Our Ref: EN020024

### **Application by National Grid for an Order Granting Development Consent for the Yorkshire GREEN**

#### **Advice following issue of decision to accept the application for examination**

NATIONAL GRID
(YORKSHIRE GREEN ENERGY ENABLEMENT PROJECT) ORDER
ACCESS, RIGHTS OF WAY AND PUBLIC RIGHTS OF NAVIGATION PLAN
REGULATION 5(2)(k)
SECTION E, SHEET 4 OF 7

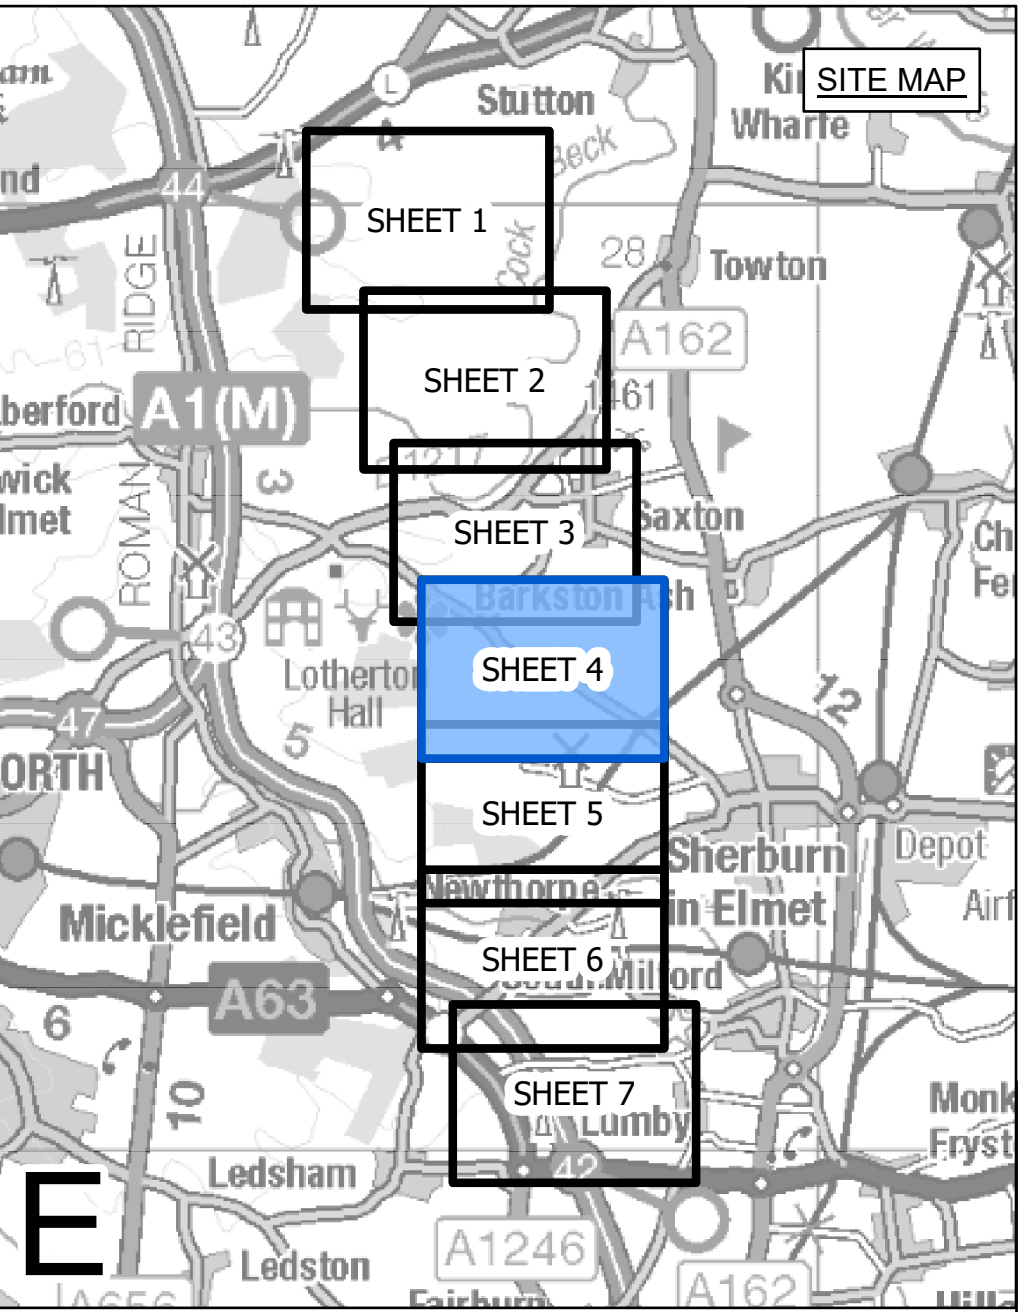
A consistency check of the Access Rights of Way and Public Rights of Navigation Plans with Schedule 7 of the dDCO should be conducted. The Inspectorate has noted discrepancies between the plans and the dDCO. For example, AP20 and AP21 are listed in Schedule 7 of the dDCO as being on sheet F4, however they are on sheet E4 of the plan. AP22 and AP26 are listed in Schedule 7 of the dDCO as being on sheet F3 but appear of sheet E4 of the plan.
